City of Portland, Maine - Building or Use Permit Application
389 Congress Street, 04101 Tel: (207) 874-8703, Fax: (207) 874-8716

Permit No: 06-0088	Issue Date: MAR 20 2006	CBL: 371 A047001
-----------------------	----------------------------	---------------------

Location of Construction: 83 BALLPARK DR	Owner Name: HAVERTY MARY MARGARET I	Owner Address: 67 HAVERTYS WAY CITY OF PORTLAND	Phone:
Business Name:	Contractor Name: Matthew Flaherty	Contractor Address: Portland	Phone:
Lessee/Buyer's Name	Phone:	Permit Type: Miscellaneous	Zone: R-2

Proposed Use: Build a 24' x 40' accessory storage and Concession building to existing ballfield.	Proposed Project Description: Build a 24' x 40' accessory storage and concession building to existing ballfield
---	--

Building to  
 be 50' off fence  
 in line with field.  
 MEASUREMENTS FROM  
 PROPERTY LINES TO BUILDING  
 SCALE OF THIS PLAN 1" = 100'

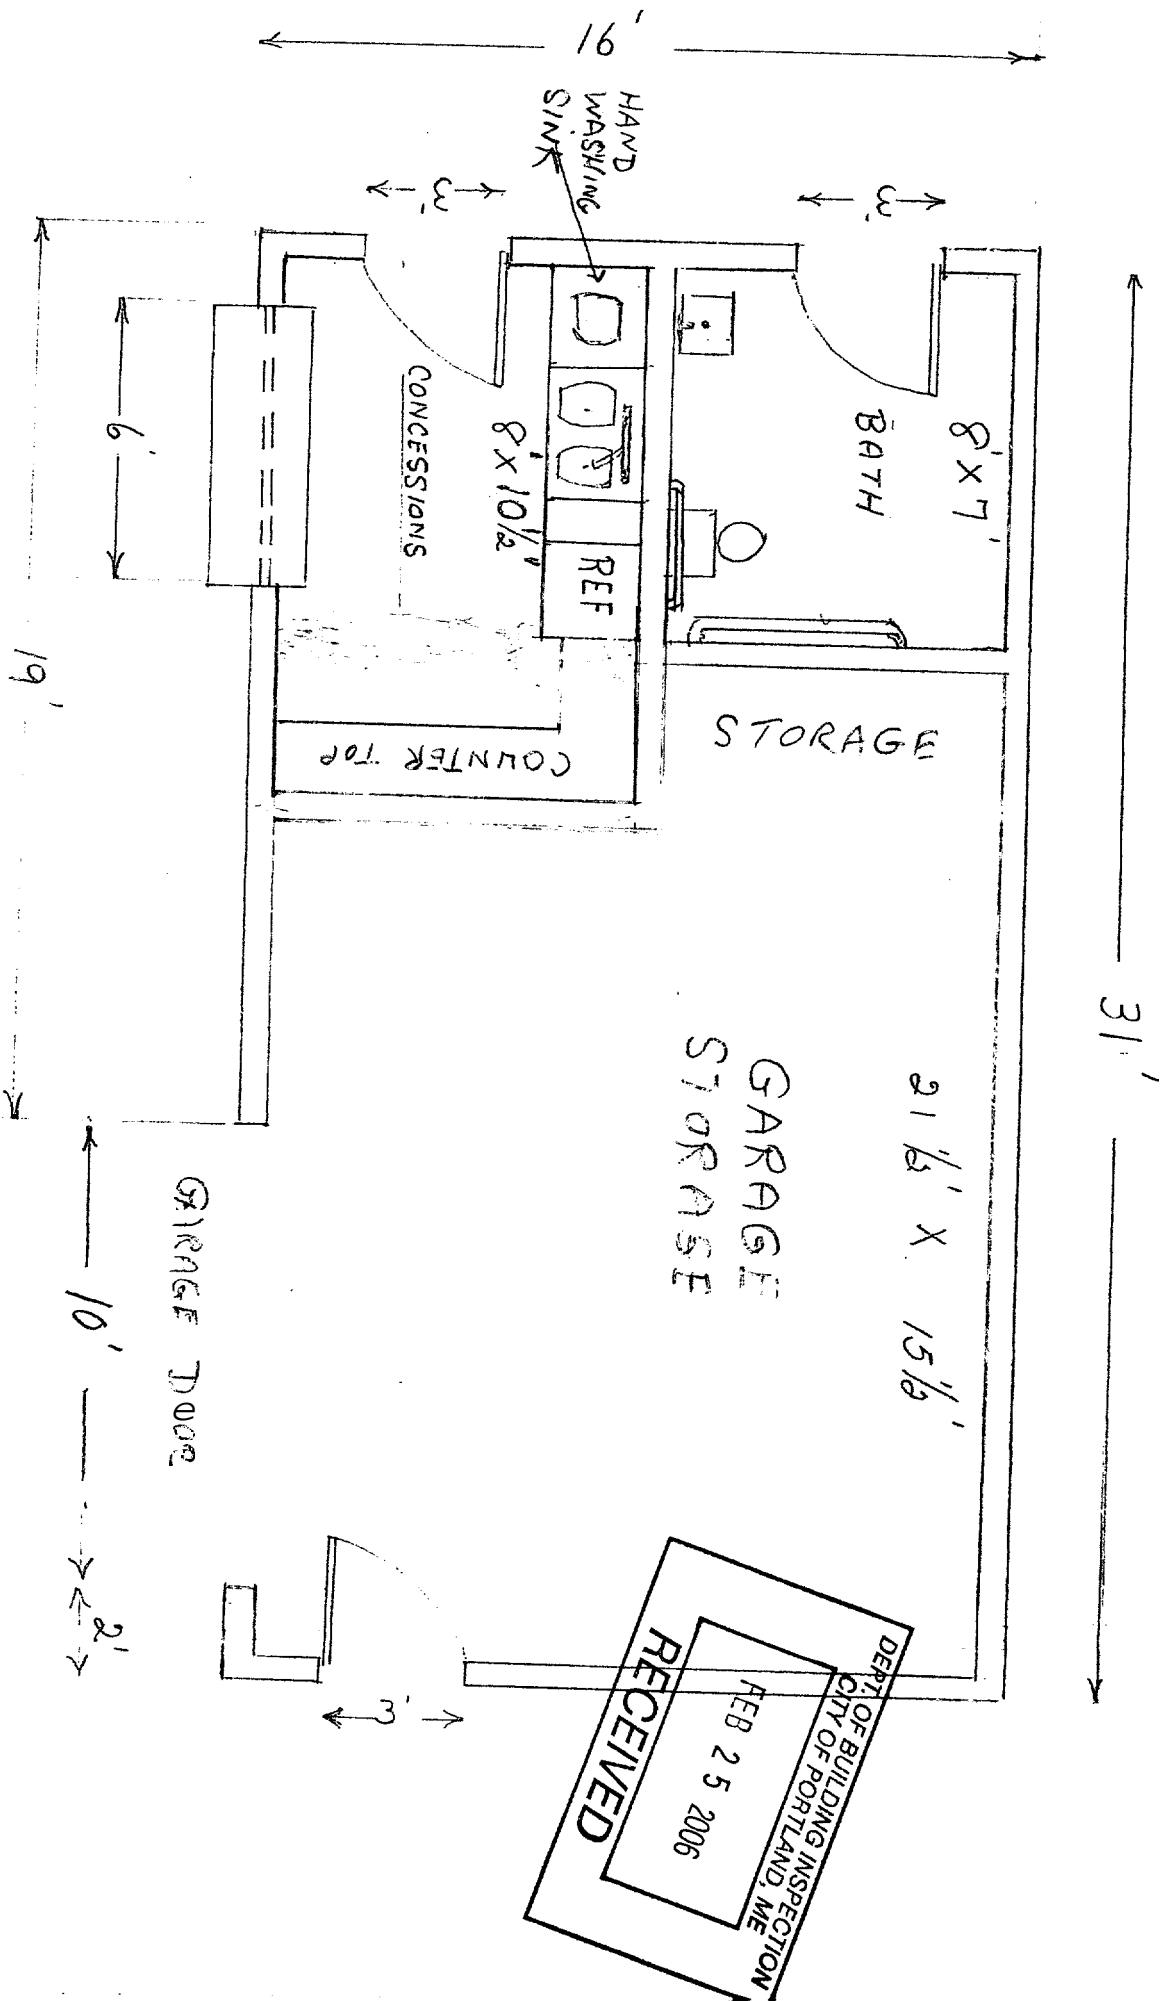
02/13/2006-jmb: Spoke w/Matt F. About inconsistency of the building size. He confirmed it is under 500 sf at 16' x 31'. He will bring in revisions and reduced plans. Also talked about FSE plumbing requirements based on the intent of chips, soda, hot dogs. No grill or range. Also need the HHE 200 application for septic.

1. Updated site plan. We moved the location of the building slightly based on feed back from contractors. It is now even further from our neighbors increasing the set back. I assume this is not an issue seeing that the required set back is 25' and we are at least 150 feet.
2. Based on feed back from a few baseball nuts, we have adjusted one wall giving the concessions area more room and storage a little less.
3. We added the hand wash sink as you had requested.
4. Enclosed the septic design prepared by Mark Hampton Associates.
5. Added to the site plan is general location of the well and possible water holding tank (if needed based on flow results from the well) we will not know this until we drill.

SUBSURFACE WASTEWATER DISPOSAL PLAN

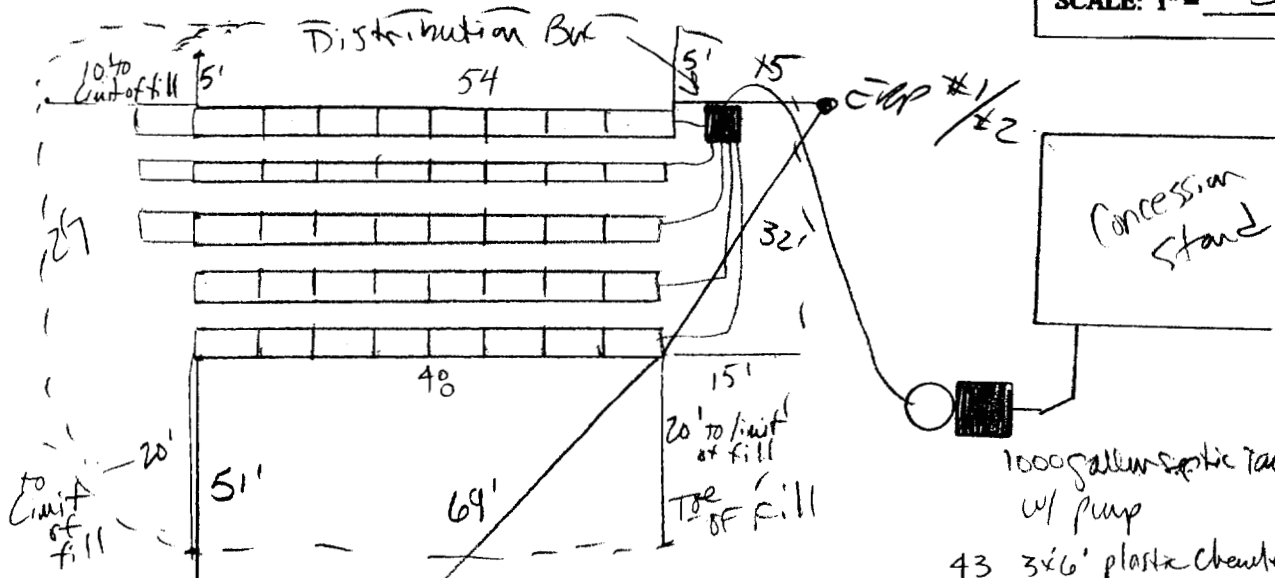
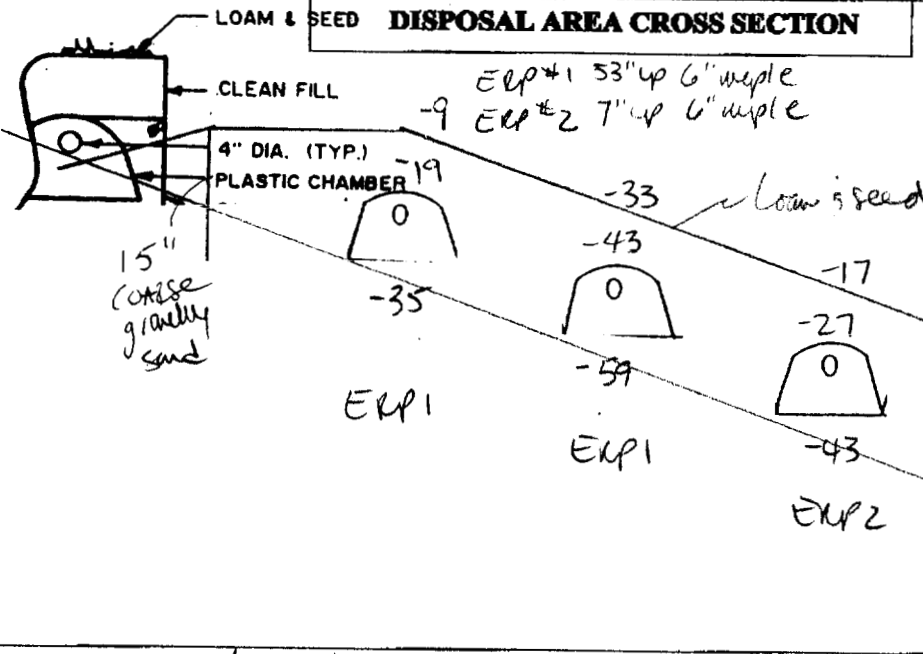
02/16/2006-jmb: Received revisions by fax and HHE 200 by mail also spoke w/Mark H. About septic details, esp. The field extensions, he will send revisions.

03/02/2006-jmb: Received HHE 200 revisions and will wait to review w/MJN before issuing, he is at a week long training. Also, Mark H. Said he is waiting to hear from the state if the septic system can be reduced in size.
